Please substitute the attached “Proposed Ground Floor Plan Rev F” for the existing version (Rev E).

Please see comments of our EH HMO Officer. These are mostly for information but I don't know whether you need to amend the plans re having an escape window for unit 3?

PROPOSED GROUND FLOOR PLAN

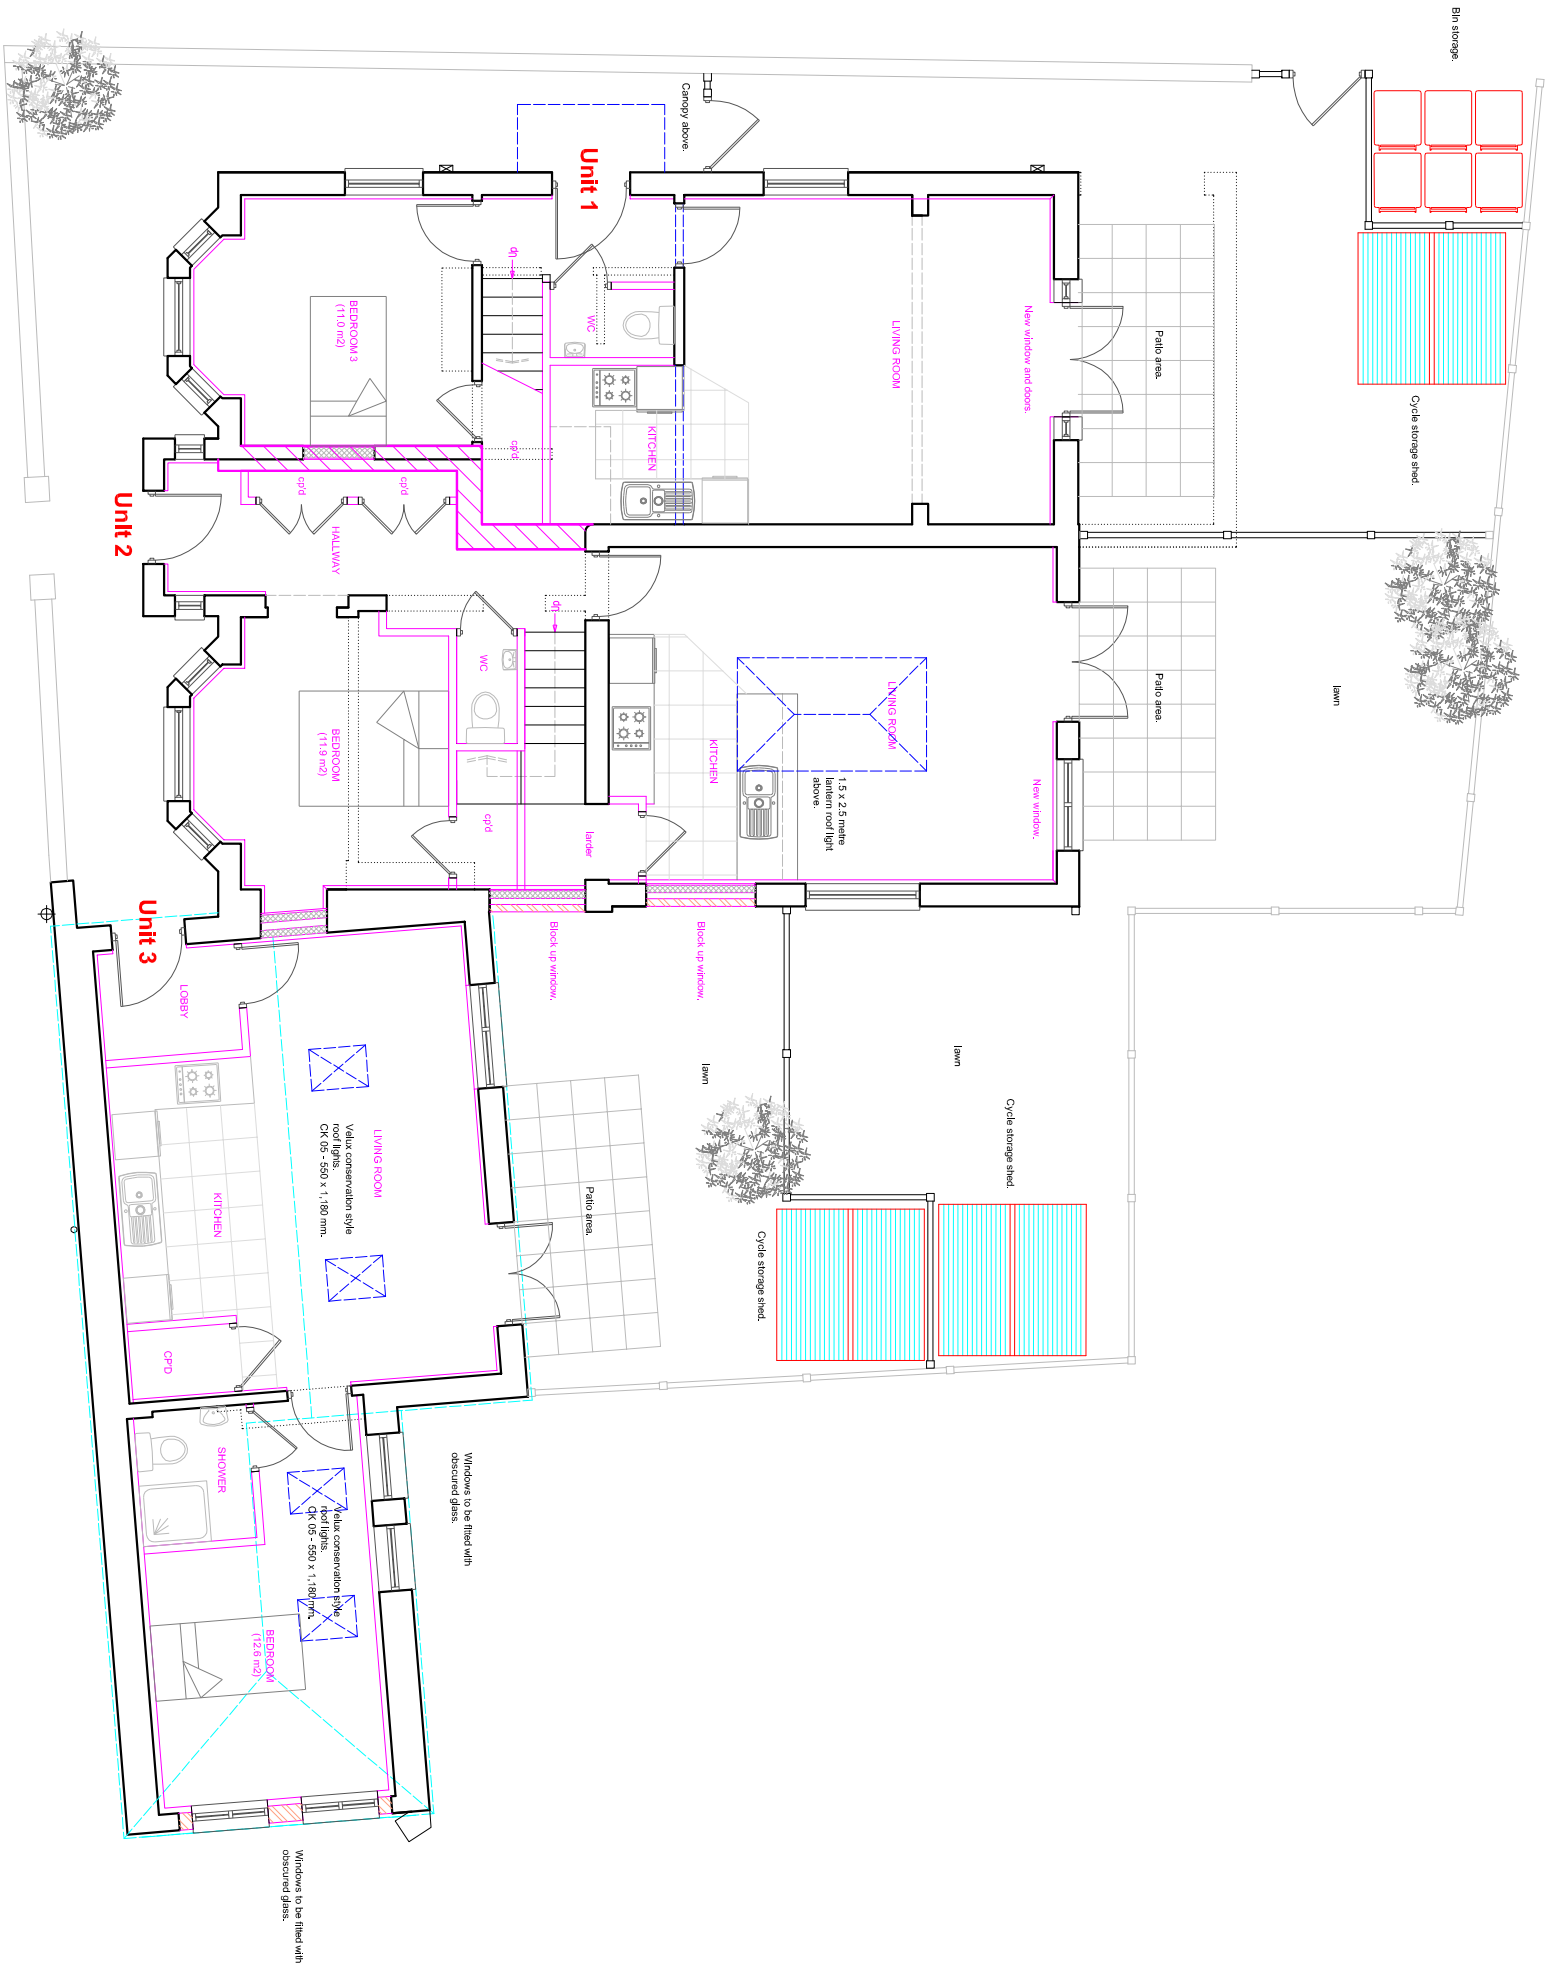
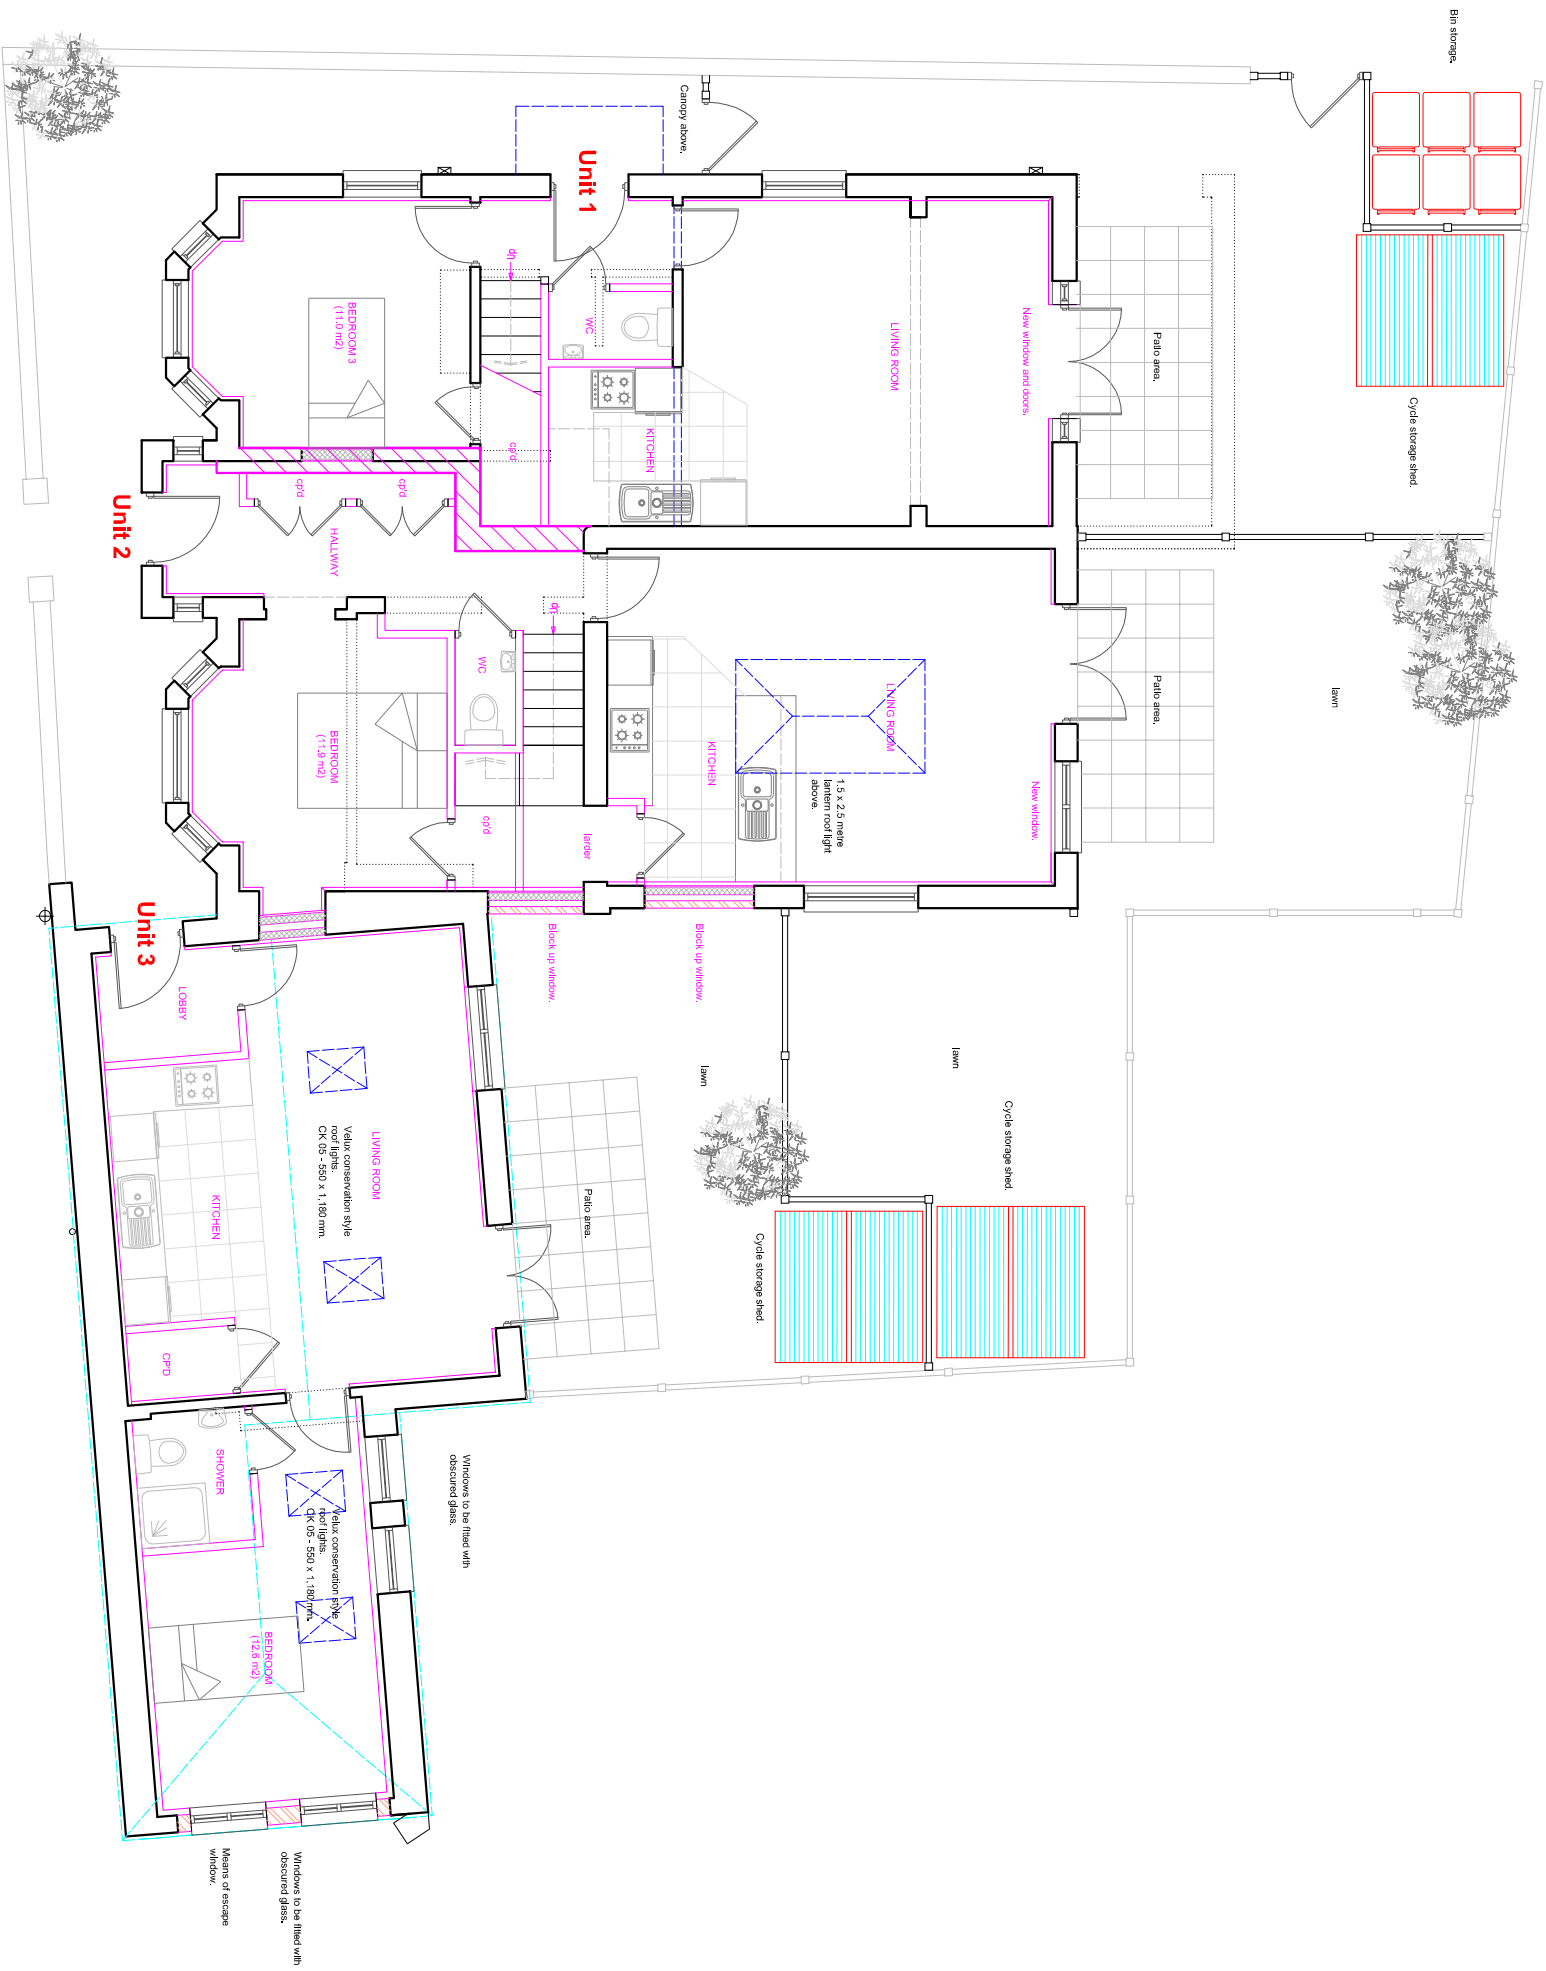
"An escape window with a sill height of not more than 1100mm from finished floor level, with an unobstructed openable area of 0.33m² and have a minimum 450mm height and 450mm width must be provided in the bedroom of unit 3."

“A window serving the bedroom to Unit 3 would need to be capable of means of escape in case of fire under The building Regulations in any case – the minimum clear area must be 0.33 m2 with no dimension (vertical or horizontal) being less than 450 mm. Cill height is to be between 800 and 1,100 mm from internal floor level.

The casements sizes are fairly narrow – if a single casement does not give the 450 mm width, the window will need to open as a whole (fixed mullion) but the look can remain the same.

I attach a copy of the plan with means of escape window marked on.”
